Our Case Number: ABP-319448-24

Ár dTag | Our Ref.
TII24-126772

Re. Strategic Infrastructure Development – Proposed Development of an 8 no turbine wind farm development and associated works on land within the townlands of Clonmellon, Kilrush Upper, Kilrush Lower, Newtown, Ballinlig, Carnybrogan, Cavestown and Rosmead, County Westmeath and Galboystown, Co. Meath

ABP Case ref. PA17.319448

Drawing file: SLR Drawings / ABP-314271-22.PL23-1.4.Node 7 Access Layout N52.pdf

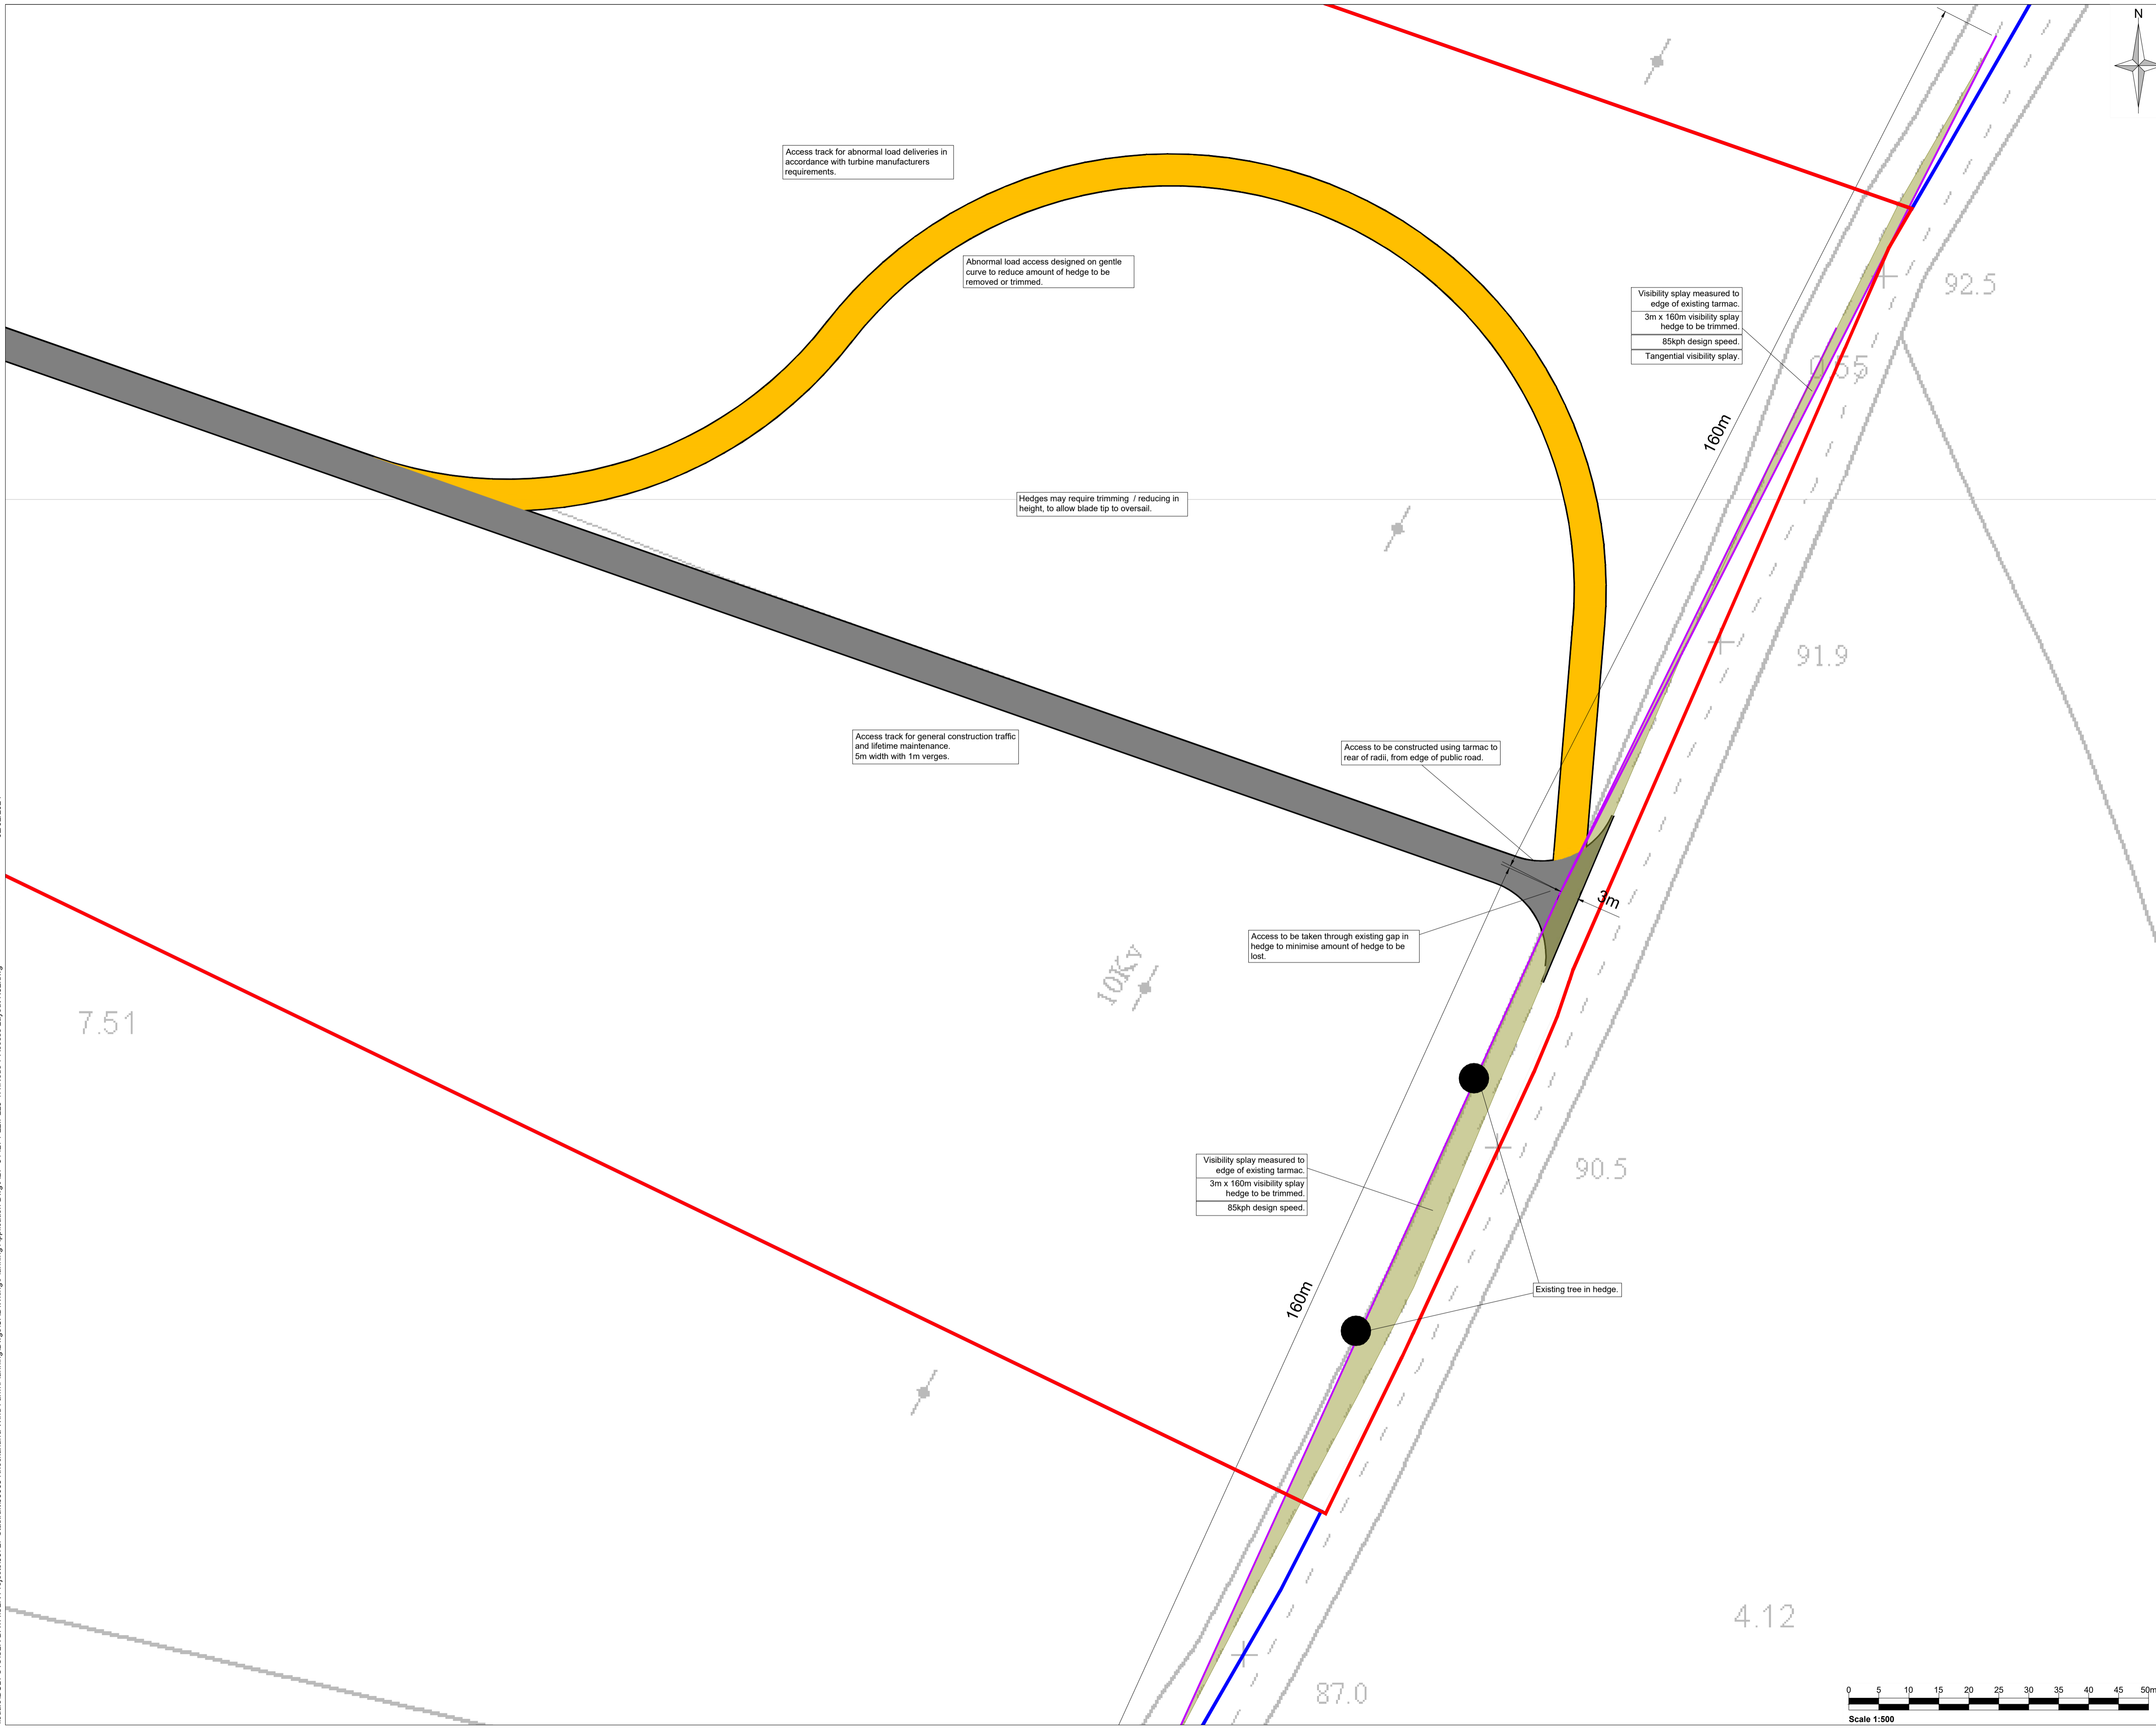
In relation to the subject application, it is noted the Section 2.9 of the EIAR identifies the inclusion of a new site entrance to T8 from the N52, national road, via an existing agricultural access within the townlands of Cavestown and Rosmead. The proposed access is detailed on EIAR Figure 14-4 as ‘Site Entrance 3’.

TII’s records indicate that an 80kph speed limit applies to the section of N52, national road, concerned.

The EIAR does not appear to address the obvious policy conflict arising from the proposed access direct to the N52, national road, at an 80kph speed limit location and this issue is not reflected in the summary of TII's EIAR Scoping submission (EIAR Table 14-1) which identified the need to address this issue in any application.

In addition to the foregoing, TII has no record that a Design Report has been submitted in relation to the proposed alterations to the N52 comprising the formation of a direct private access. TII Acceptance of a Design Report for such works to a national road is required as set out in TII Publication GN-GEO-03030 (www.tiipublications.ie).

- TII is not aware of any Road Safety Audit being completed for the development access to the N52, national road. It is critical that road user safety on the national road shall be safeguarded. TII recommends that a Road Safety Audit should be undertaken, and all recommendations of the Road Safety Audit shall be incorporated into final designs for construction and the requirements to implement the recommendations of the Road Safety Audit included as a condition on any permission granted.

- The developer shall submit revised documentation which shall demonstrate that all works to the national road shall comply with TII Publications (formerly NRA DMRB); technical design standards for national roads, including Design Report requirements in accordance with TII Publications GN-GEO-03030.
